STATUTORY PLANNING CONSULTATION RESPONSE

Application Number:	3/2026/0400
Proposal:	Approval of details reserved by conditions 15 (surface water operation and maintenance); 16 (surface water verification report); and 17 (new build units verification) on planning permission 3/2022/0966.
Location:	Crow Trees Farm Crow Trees Brow Chatburn BB7 4AA

Lead Local Flood Authority Position

Client: Pringle Homes
Project: Crow Trees Farm, Chatburn
Drawing Title: Foul and Surface Water Drainage Plan

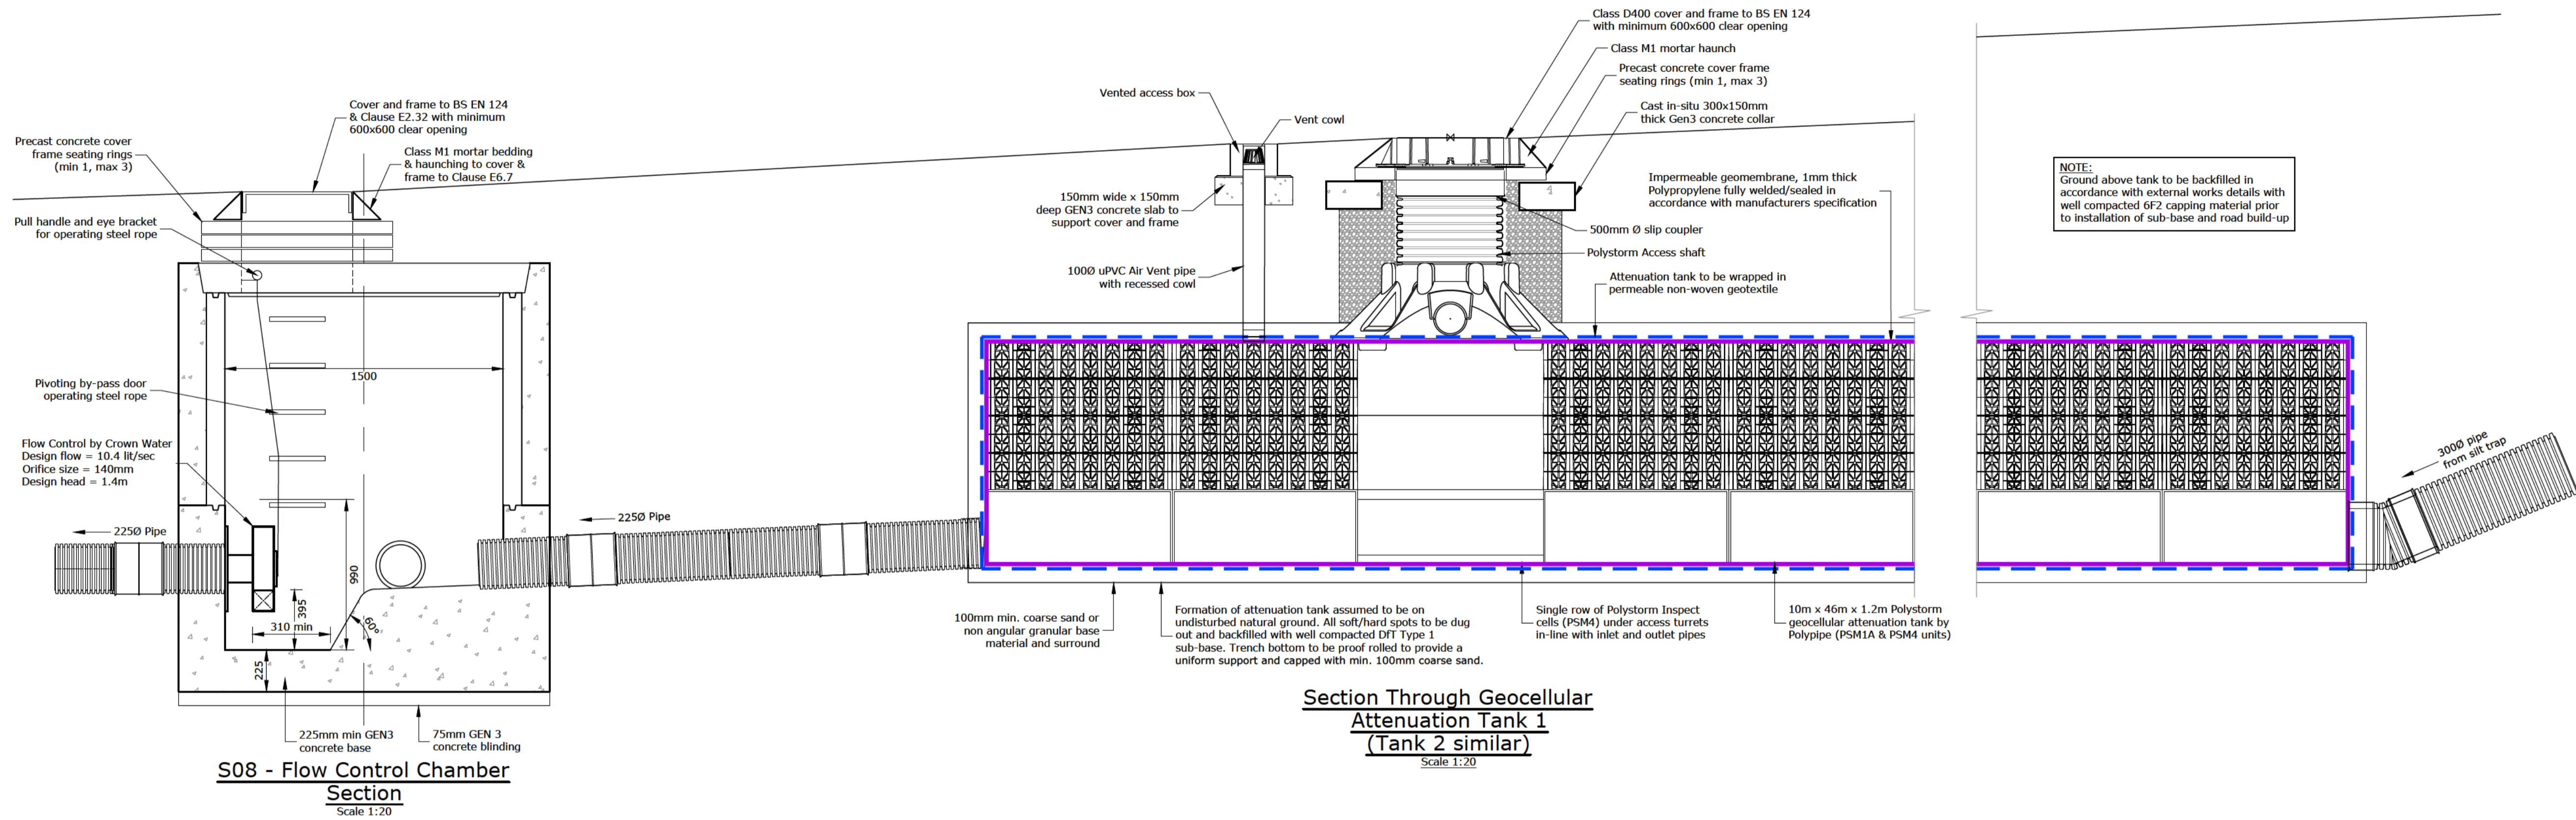
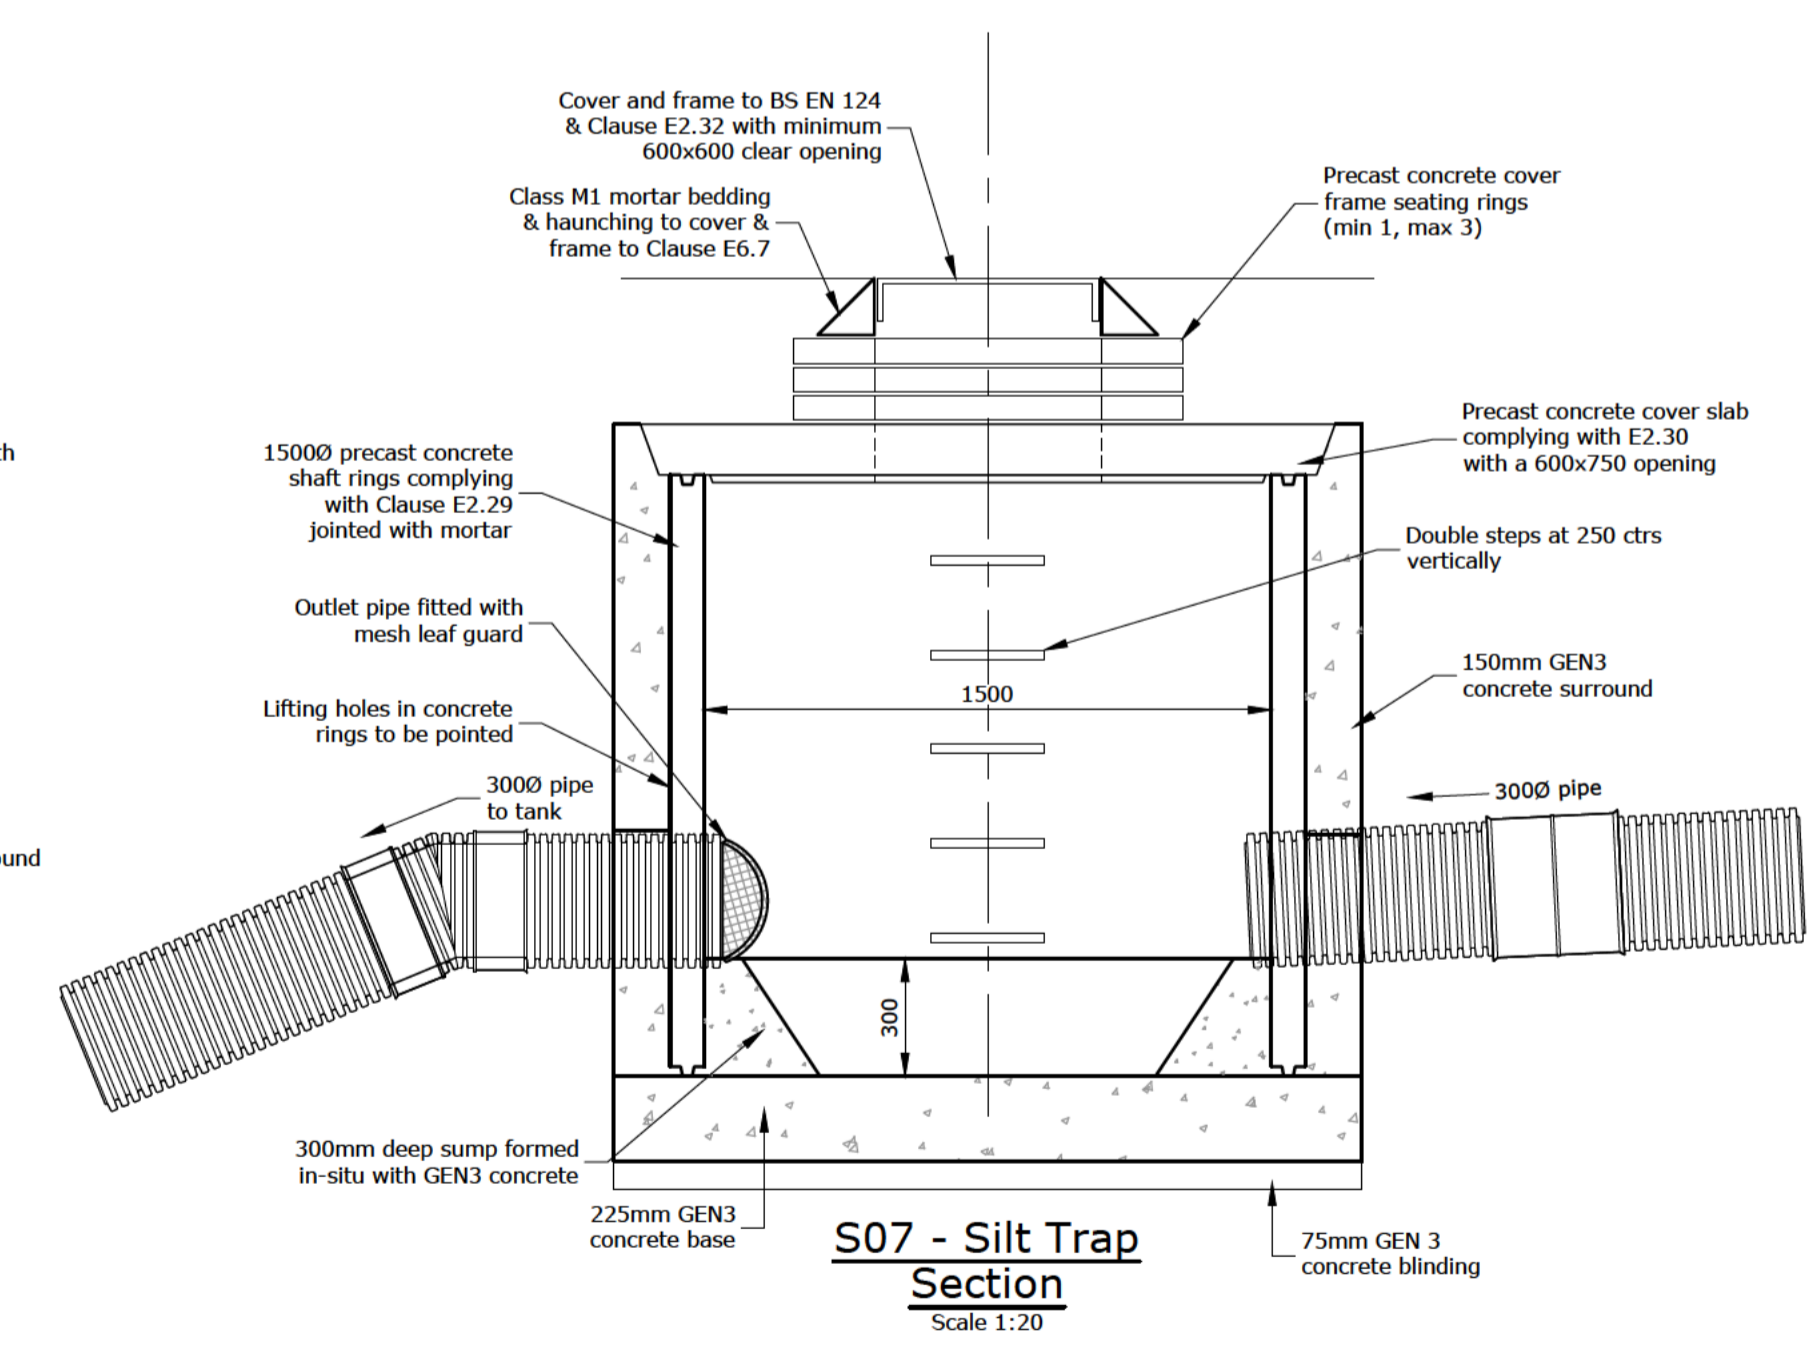
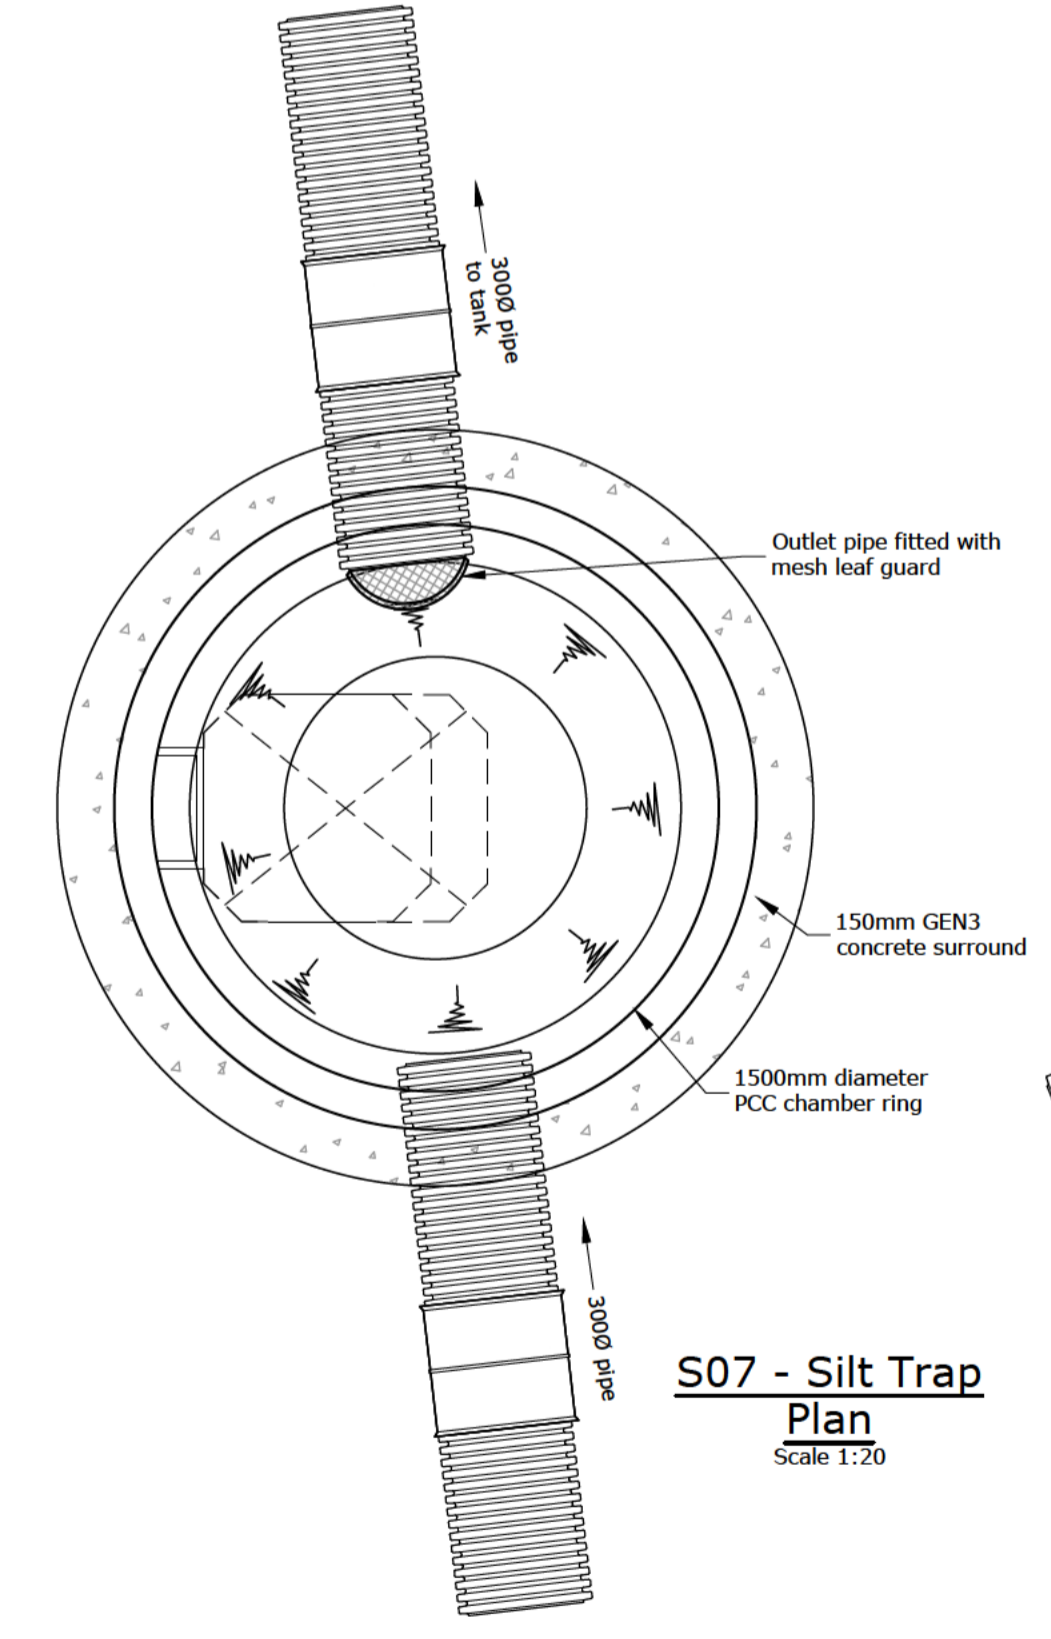
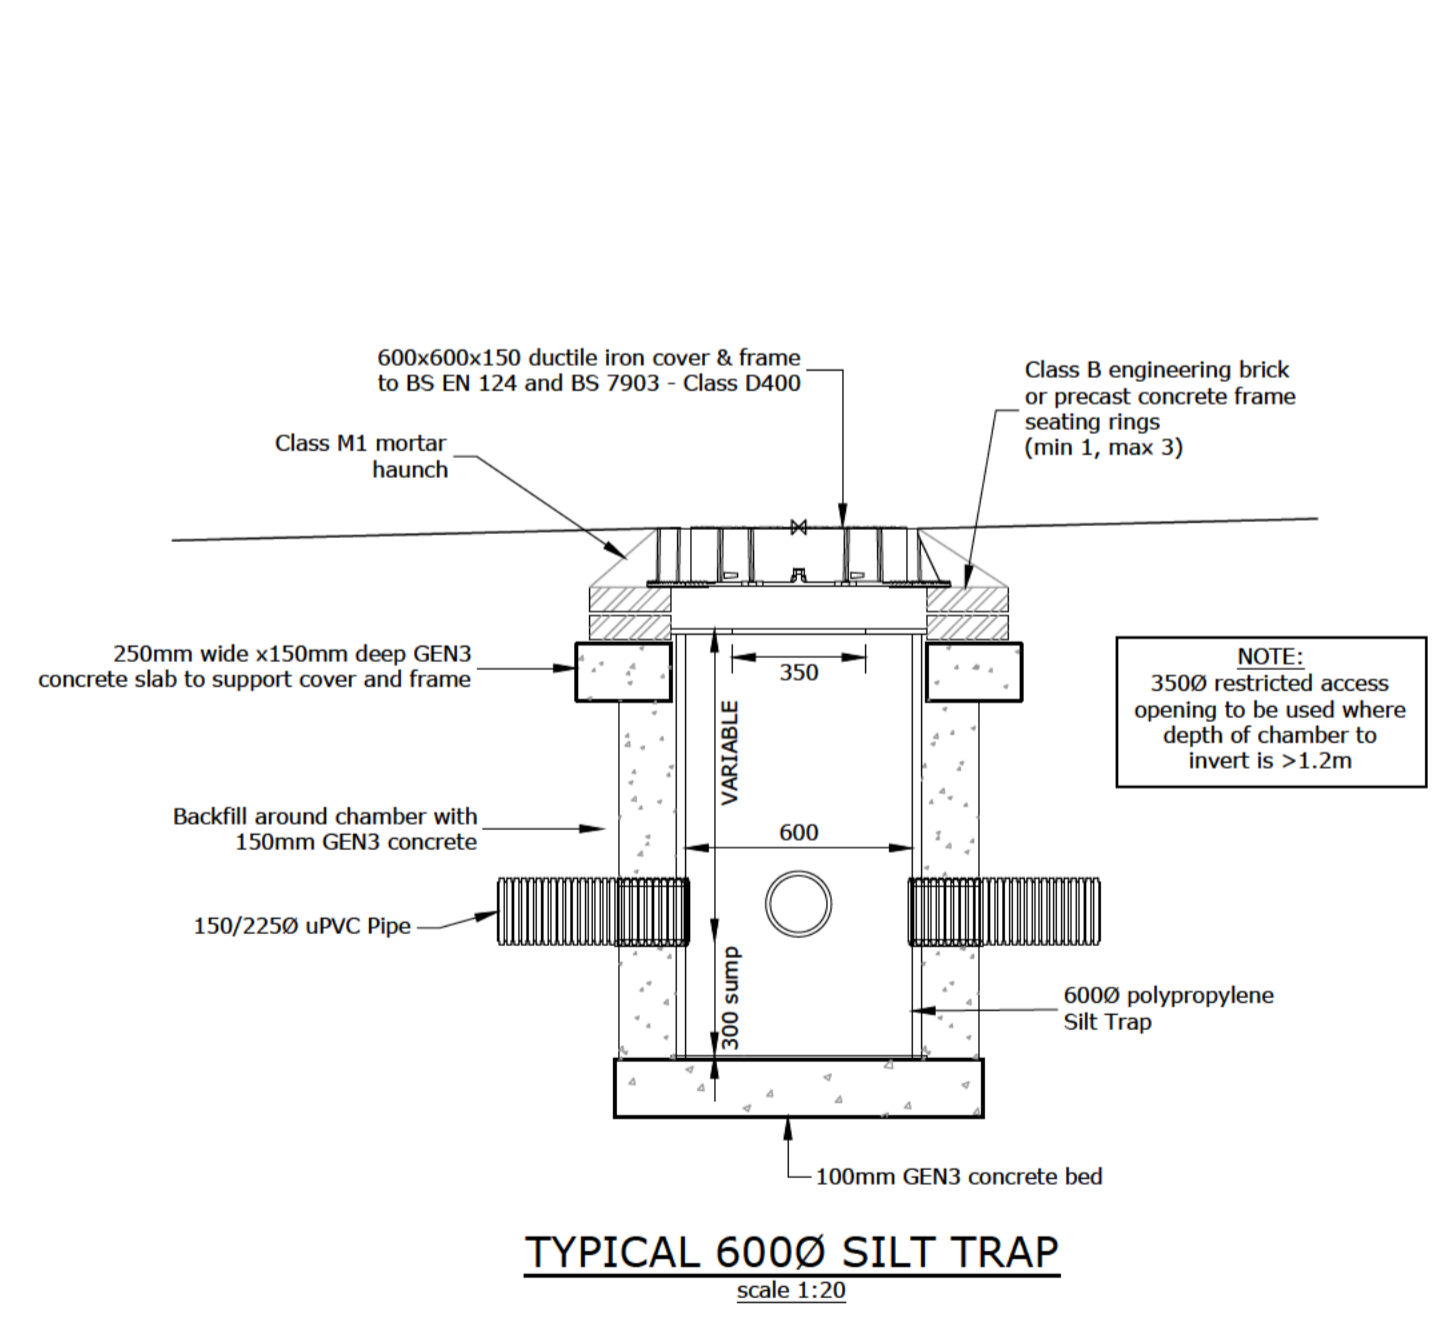
- The applicant has failed to provide clear and robust justification for the changes and the deviation in the proposed surface water sustainable drainage design, from the approved design (Foul and surface water drainage plan / K39346 – 20 / 21st March 2024 / RG Parkins) through the discharge of condition 13.

For the avoidance of doubt, the applicant has demonstrated that the development now discharges both foul and surface water into the same system before leaving the development, which is contrary to foul and surface water systems being drained through separate systems to their final discharge location, regardless of this final discharge location being a combined sewer. At this stage it is also unclear if the applicant has given due consideration to the implications of combining of these systems, as no non-return valve is evident to prevent foul water entering the surface water system in event of a blockage, surcharging or increased rainfall.

In addition to this, the applicant has provided evidence which demonstrates that the development may be discharging at a rate greater than the agreed greenfield rate, as there are both foul and surface water systems connecting into manhole C03 after the systems have been restricted by the necessary hydro brakes.

- The applicant has failed to provide evidence which accounts for the proposed deviation in design as outlined above, as this could have a direct impact on the management and maintenance of the surface water sustainable drainage system, in perpetuity.
